Recommendation Report for Planning Permission for Works or Extension to a Dwelling

REF NO: AW/61/19/HH

LOCATION: 7 Hechle Wood
Aldwick
PO21 3TL

PROPOSAL: Single storey rear extension

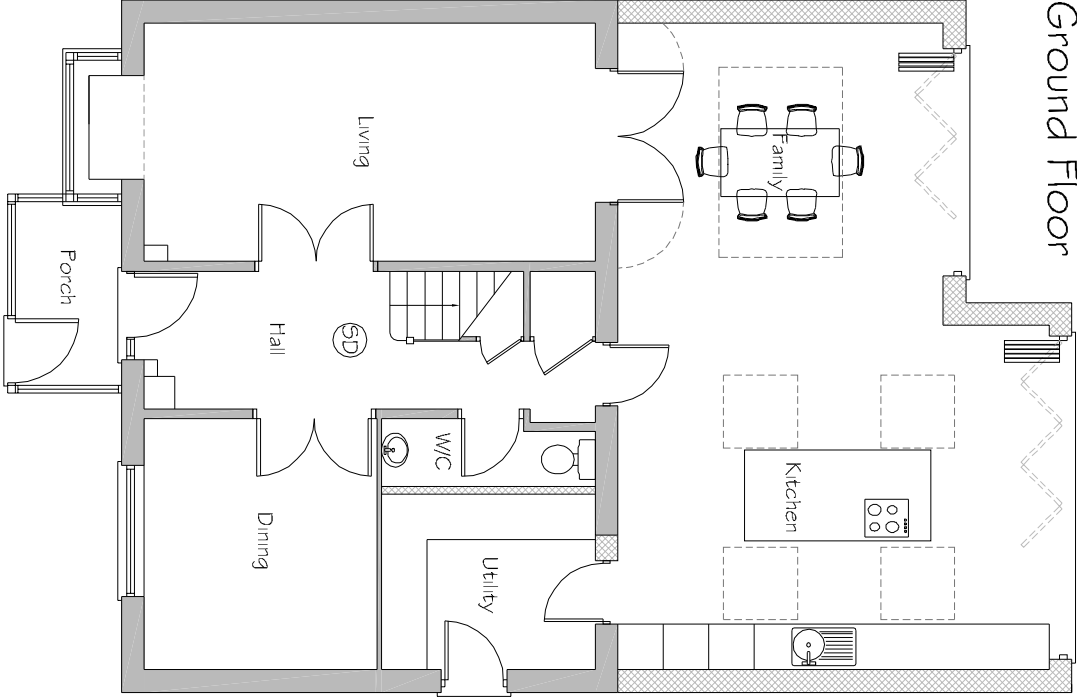
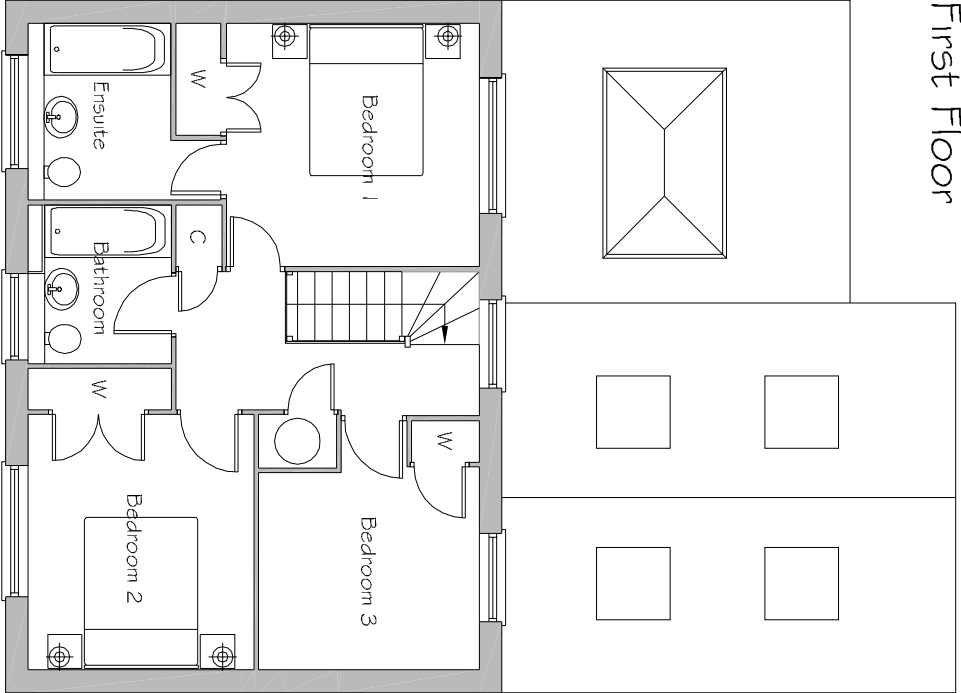
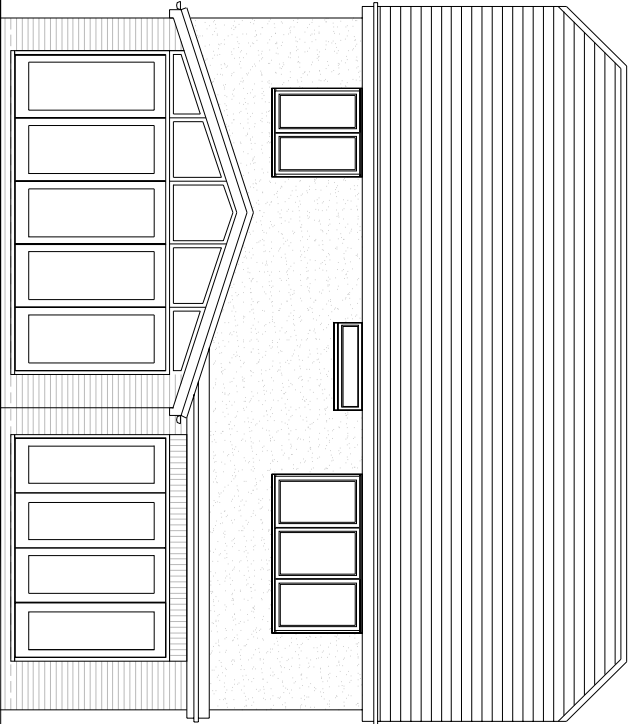
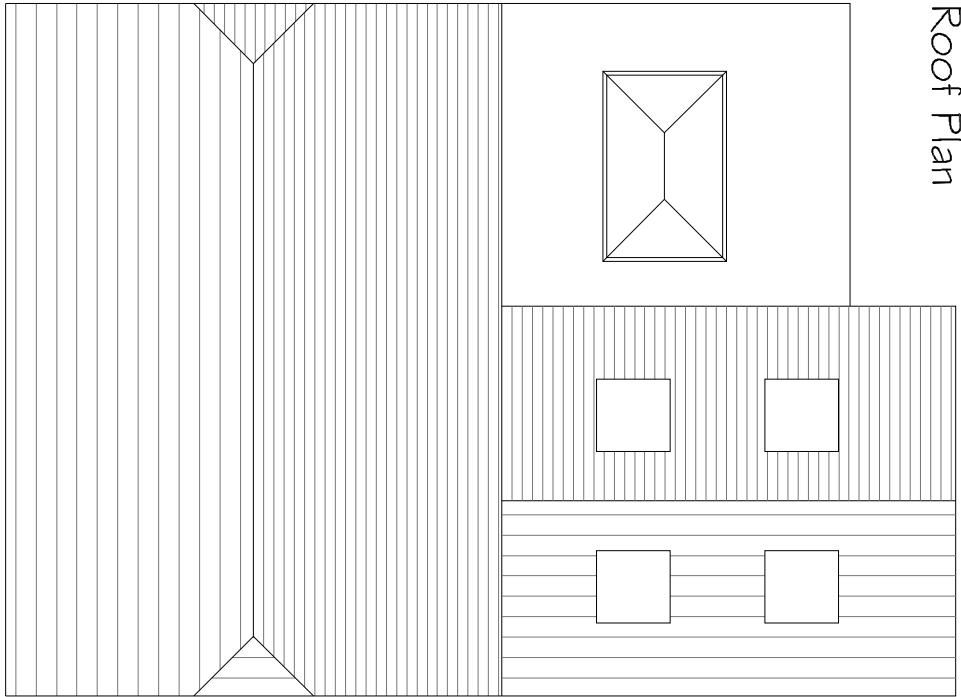
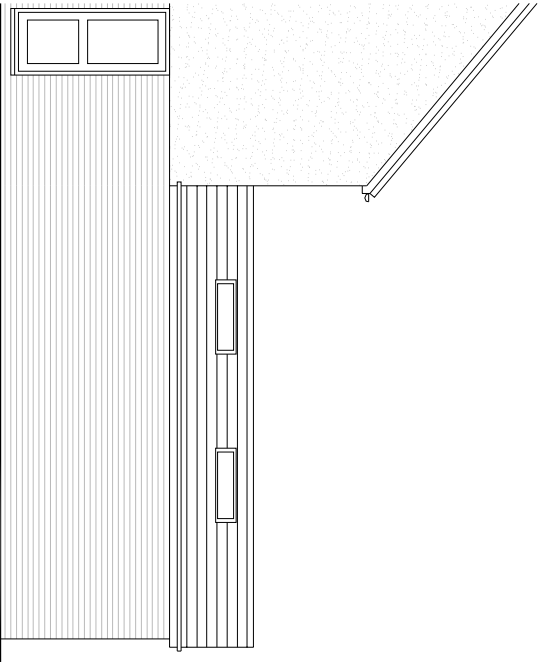
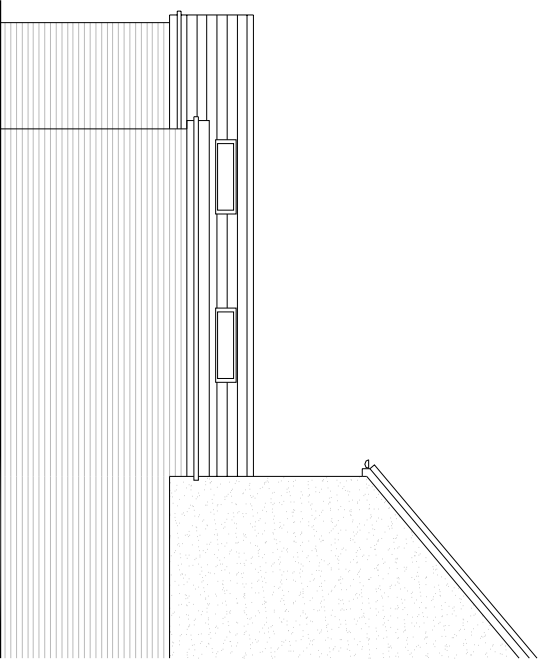
The extension will run along the rear of the dwelling at a depth of 5m where it will then reduce to 4m. Where the development extends to 5m it will have a pitched roof to a maximum height of 3.3m with eaves to 2.3m. Where the depth reduces the extension will have a flat roof to a height of 2.7m.

The extension does add a relatively large addition to the rear however due to the siting of the dwelling which is further forward than that of No.9 the extension does not extend beyond their rear elevation and as a result is not considered to appear adversely overbearing or overshadowing upon neighbouring amenity.

There will be 2 sets of doors and a window to the extension however with the development at single storey, it is not considered that there would be any views additional to that which are already available with sufficient boundary treatment also in place. The pitched roof extension would have 4 rooflights however again due to their siting above finished floor level and a sufficient distance from the neighbouring property they are also not considered to result in any adverse overlooking.
